REQUEST

Current Zoning: R-3 LWPA (single-family residential, Lake Wylie Protected Area)
Proposed Zoning: MX-2(CD) LWPA (mixed use, conditional, Lake Wylie Protected Area)

Approximately 22.87 acres located on the north side of Oakdale Road between Miranda Road and Interstate 485.

The petition proposes to allow up to 138 duplex style attached residential dwelling units at a density of 6 dwelling units per acre on parcels that are developed with single-family homes and a former golf clubhouse.

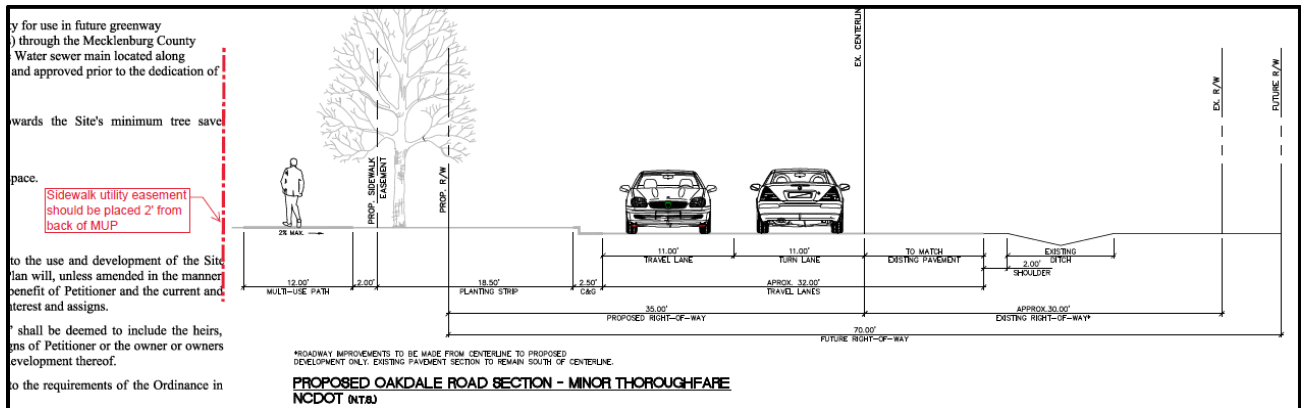
1. The petitioner should revise the proposed Oakdale Road cross section to relocate the multi-use path (MUP) sidewalk easement to 2-feet from back-of-MUP.
2. The petitioner should revise the site plan and conditional note(s) to clarify that the proposed access below will be reviewed and considered by NCDOT, during plan permitting, as either full movement or right-in/right-out. A right-in/right-out access will only be permitted if a center median is installed. If full movement, NCDOT may require the storage and taper length of the Oakdale Road left-turn lane to be extended. A detailed review will be completed during permitting.
